Notice of Modification

Section 75W of the *Environmental Planning and Assessment Act 1979*

Sydney **23 MARCH** 2015

The project approval (09_0182) for the Boggabri Coal Project, granted by the Planning Assessment Commission under delegation from the Minister for Planning and Infrastructure on 18 July 2012.

Figure 4: Additional Infrastructure Mod 4

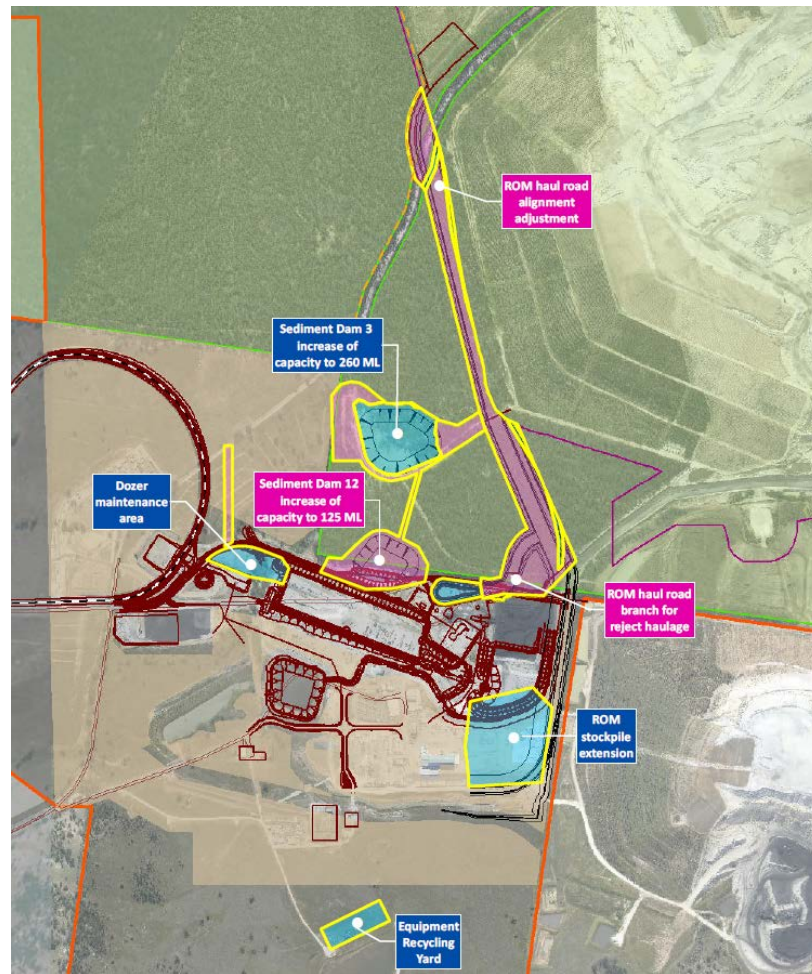
9. In Appendix 2 Project Layout Plan insert the following figure after Figure 3.

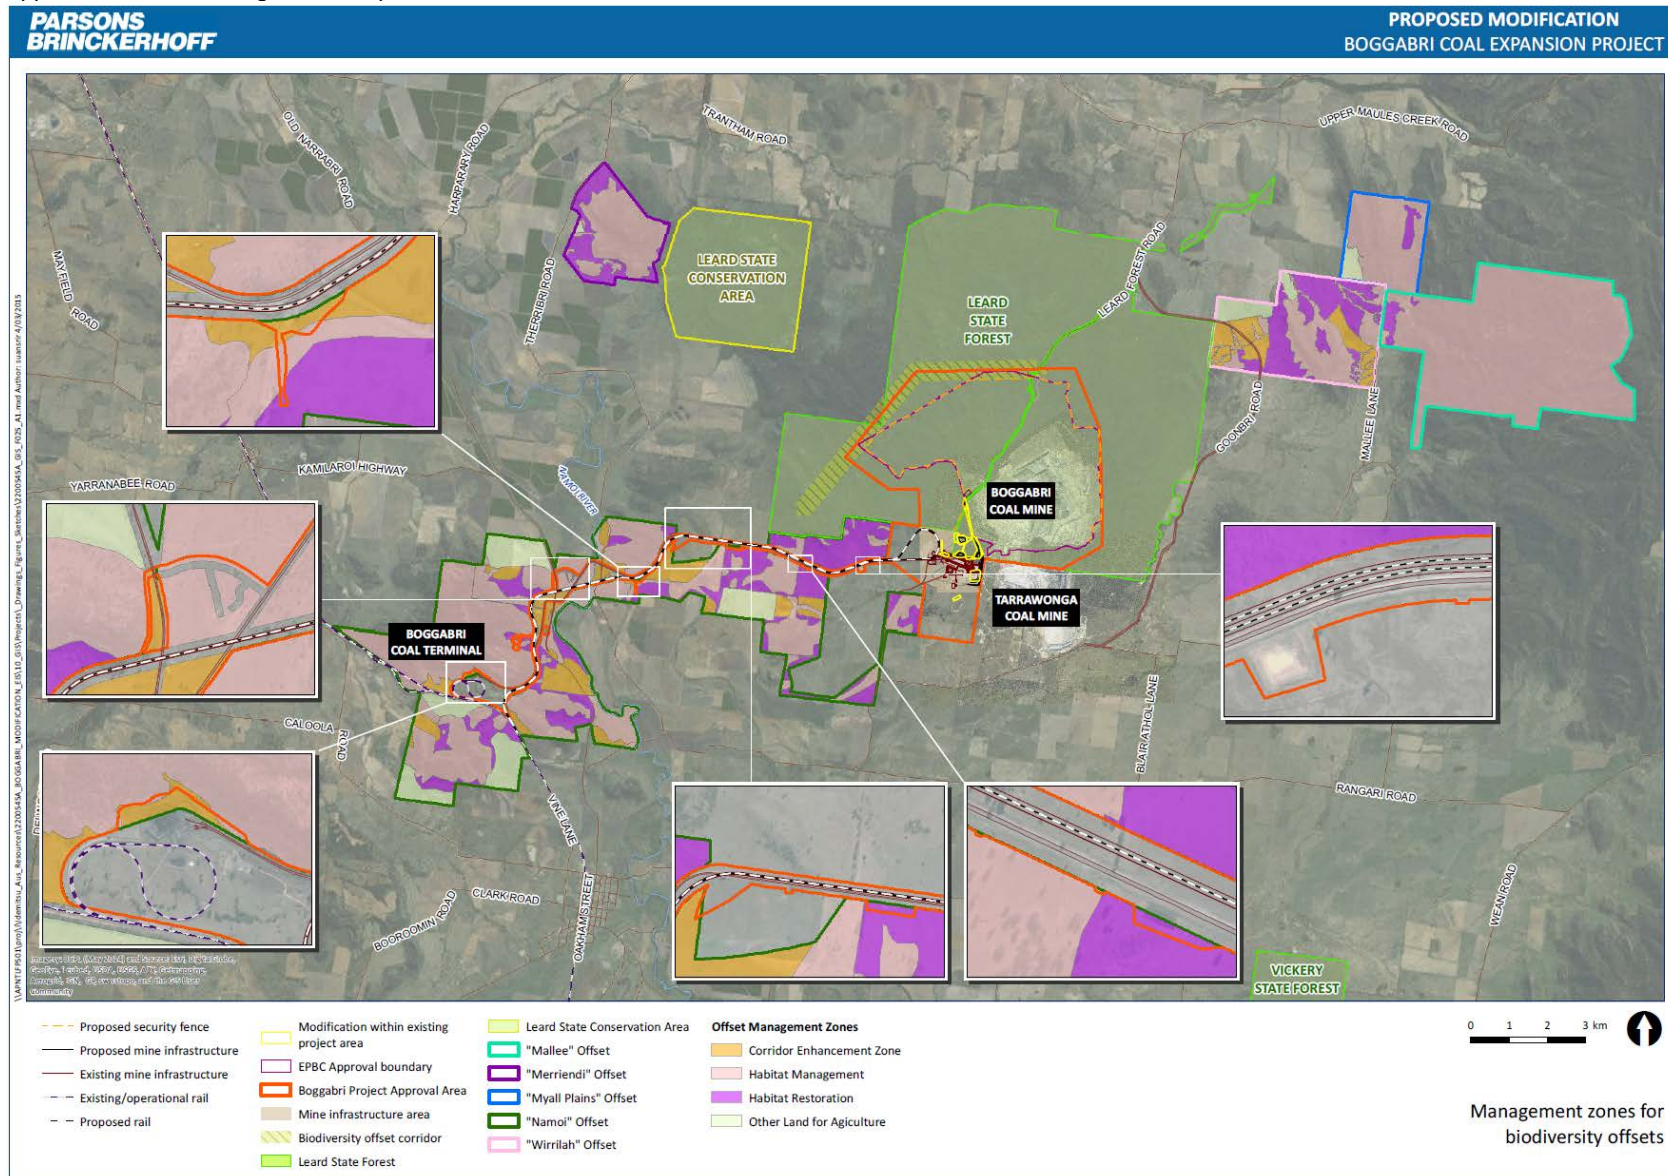
10. In Appendix 7 delete the figure and replace with:
